# V1Grading and Erosion Control Plan.pdf Markup Summary

OUTLOOK POWERS & GRINNELL
GESC - NOTES

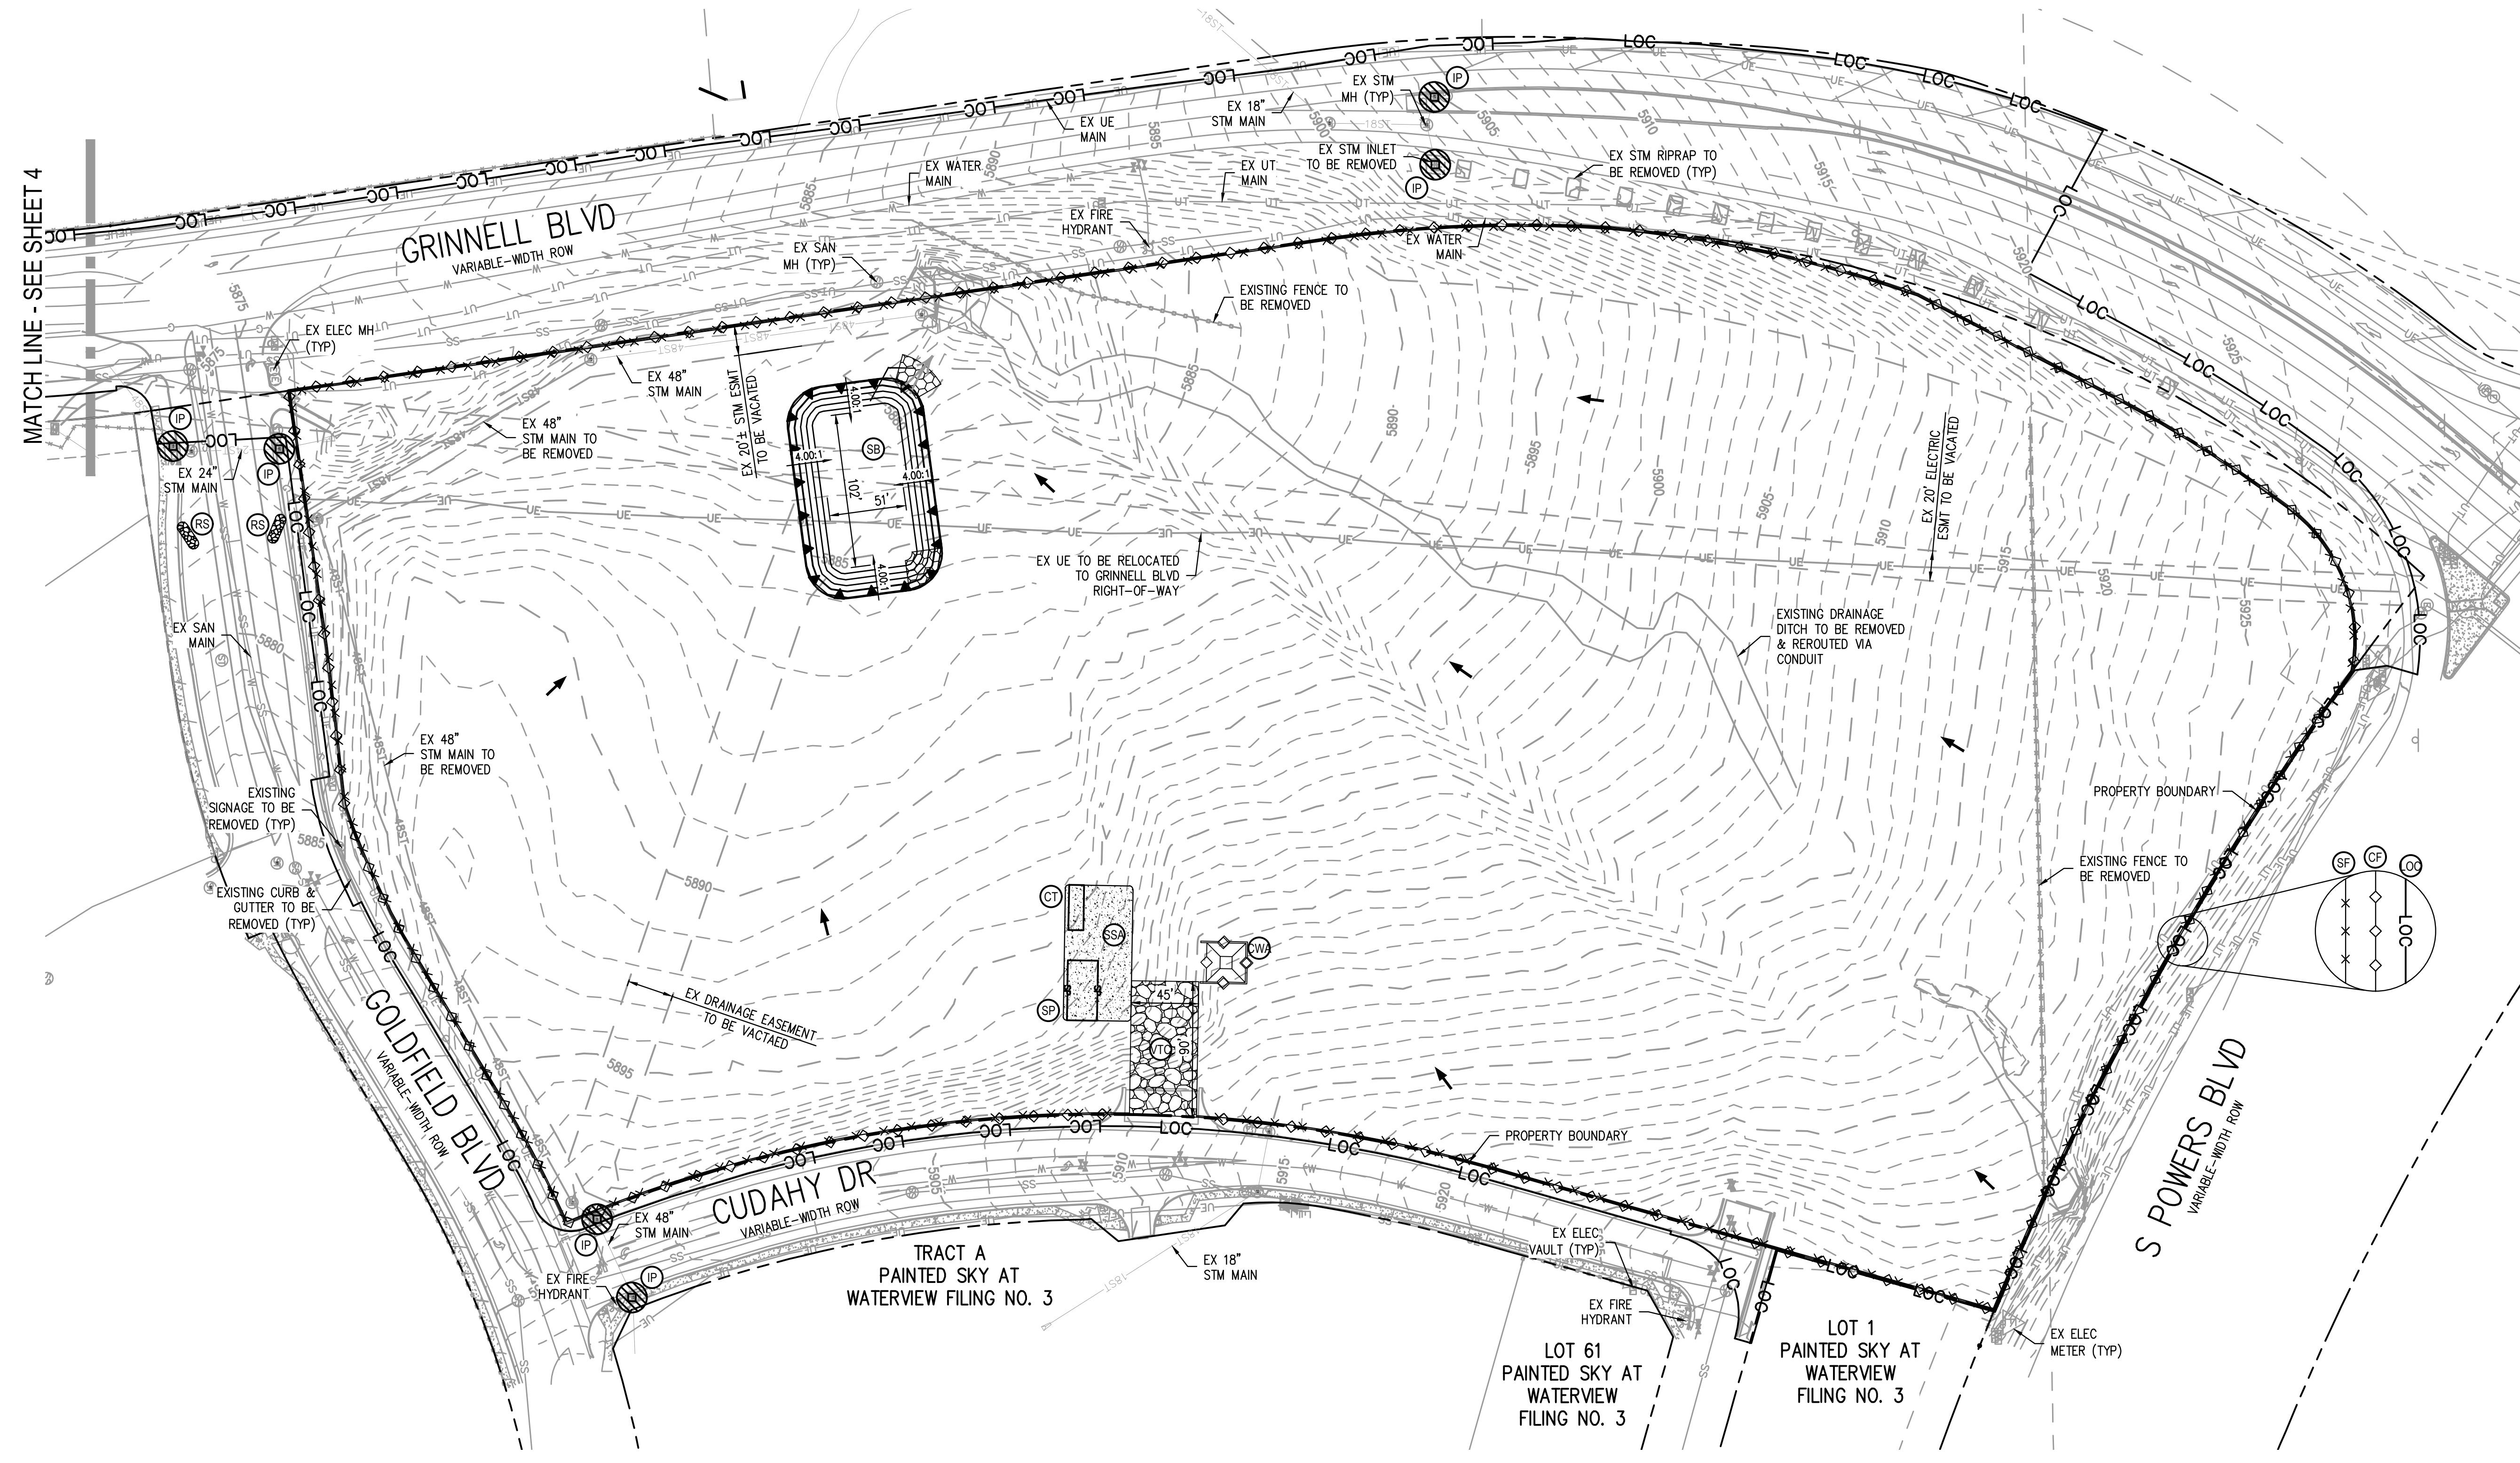
SWMP Checklist Item 17f: Add a note that states no asphalt/concrete batch plants will be utilized.

GEC Checklist Item i: Provide existing vegetation on GEC plans or add note with percent ground cover and type of vegetation.

Update the SWMP date

OUTLOOK POWERS & GRINNELL
 GESC - INITIAL

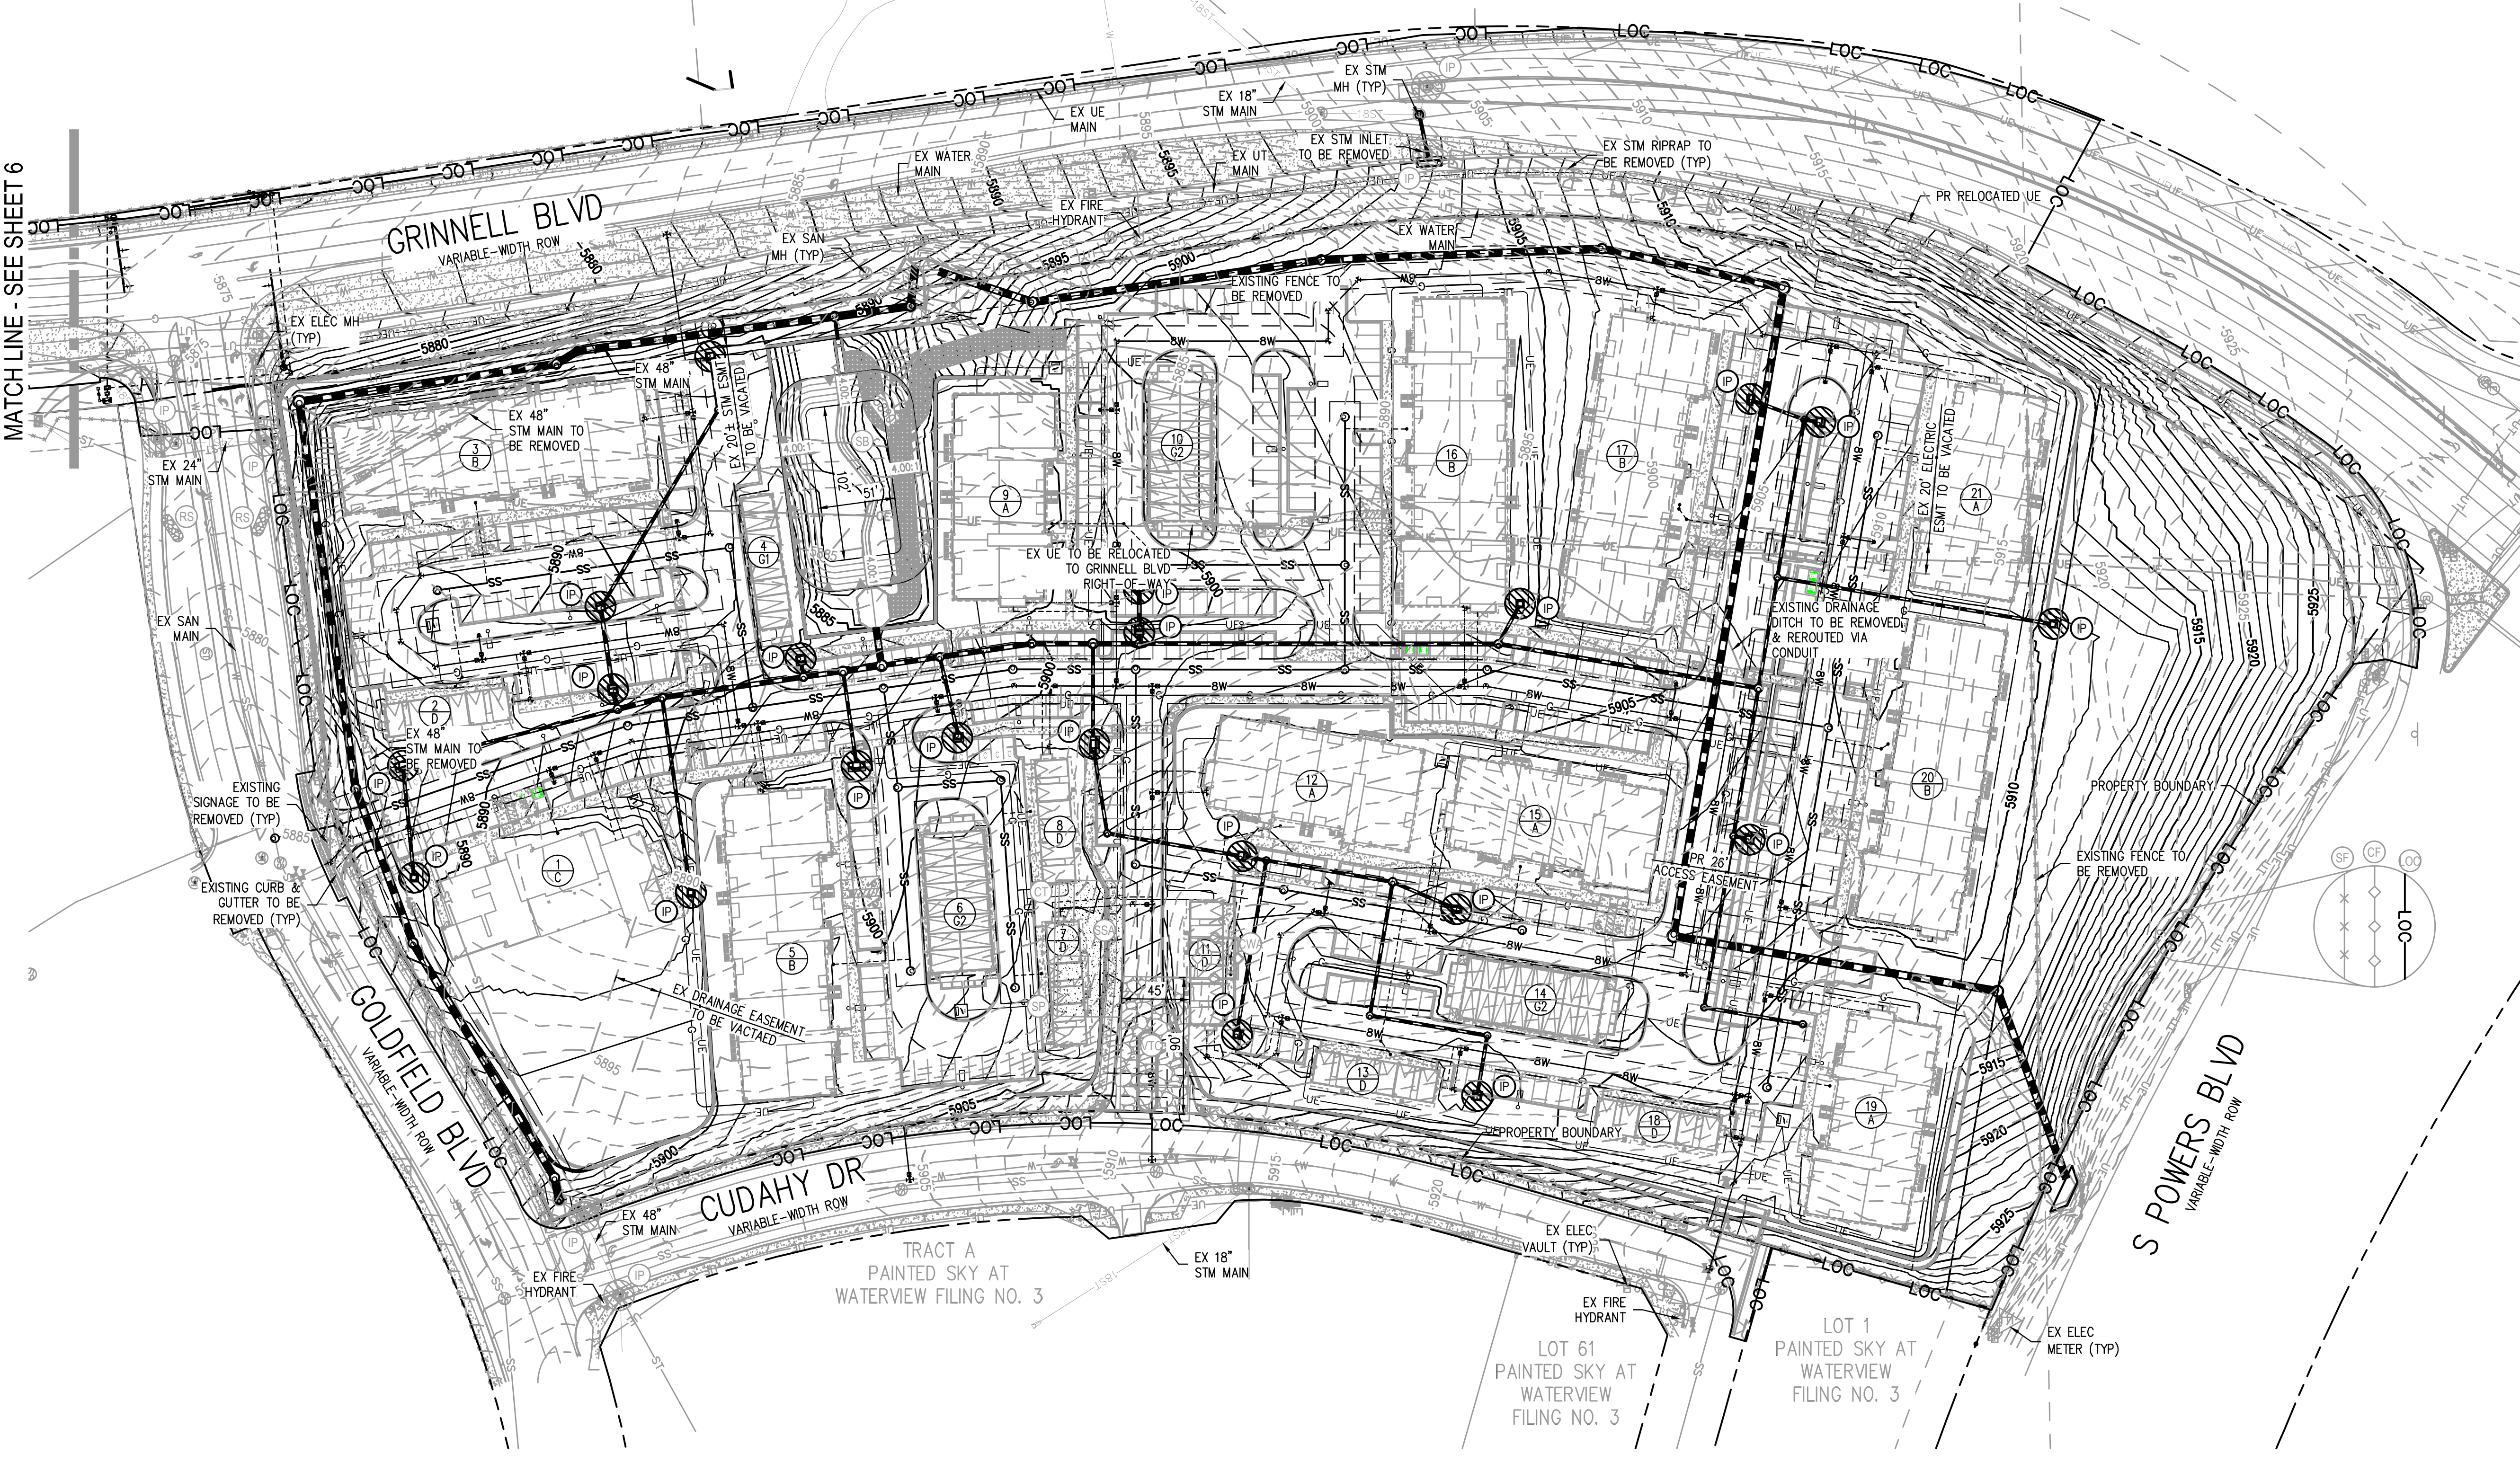
This appears to be a drainage chase/runaway. Please label and indicate if it remains or is to be removed

SWMP Checklist Item 17d - Show all areas of cut and fill on the plans.

GEC Checklist Items H and M. If "limits of disturbance" and "construction boundary" are the same, change to "limits of construction/disturbance" or otherwise show as separate line types for each on the legend and figure.

GEC Checklist Item n: Identify and protect areas outside of the construction site boundary with exist fencing, construction fencing or other methods as appropriate

GEC Checklist Item cc - show construction easements for off-site work.

Provide details for how "ditch" is to be removed. The drainageway has sever erosion approximately 10-20 feet and is not an existing ditch but an eroded channel. Incorporate information from the geotech report showing clearly how the erosion will be fixed and stabilized.

Provide design information on TSB include disturbed drainage area, undisturbed drainage area, Total required storage volume, Outlet pipe size, # columns & size of orifice holes, spillway data

Indicate if this pipe remains or is removed

OUTLOOK POWERS & GRINNELL
 GESC - INTERIM

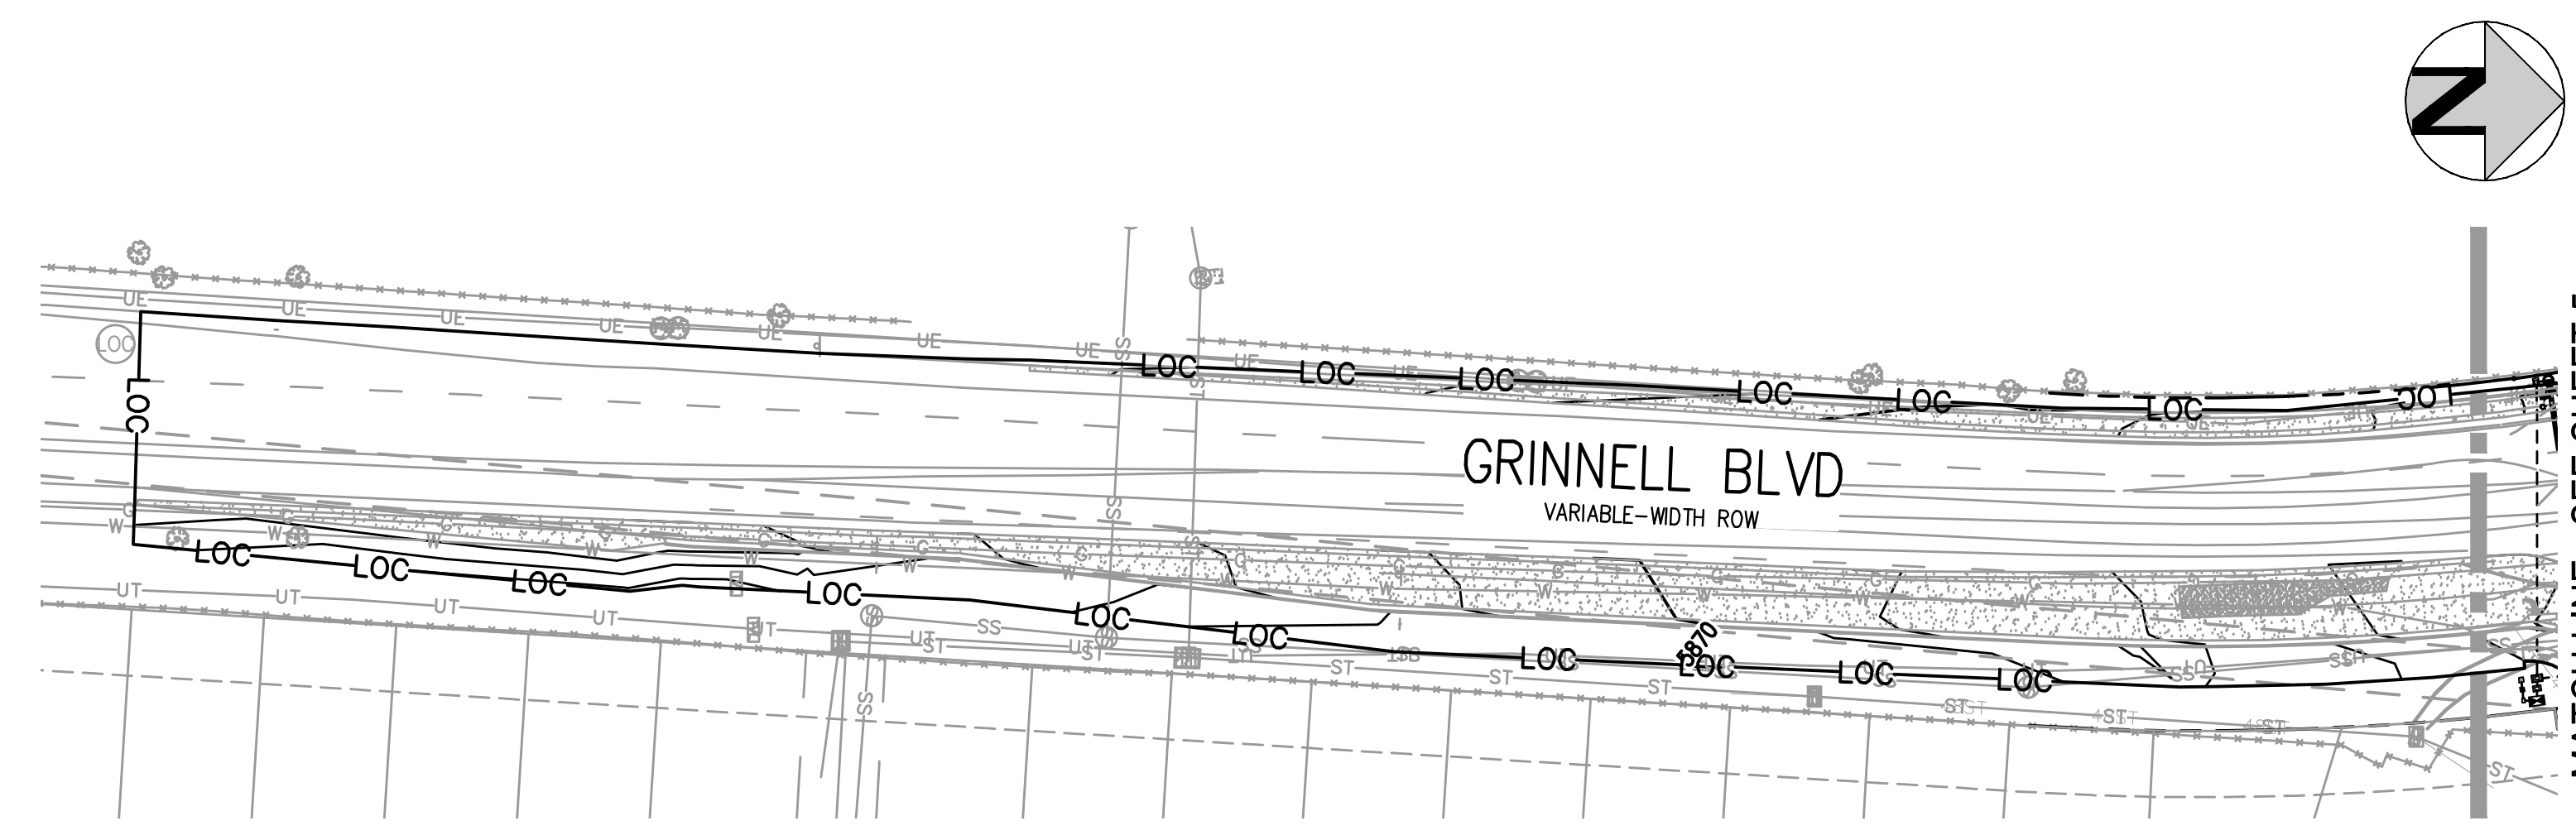
Label slopes - Anything steeper than a 3:1 slope will need to have erosion control blanket

Label slopes

Include slopes at centerline of roads

Label slopes

Per SWMP, Surface Roughening is a BMP proposed - show surface roughening areas on plans or add a note detailing what areas would require surface roughening.

GEC Checklist Item o: Call out off-site grading clearly.

Provide drainage arrows
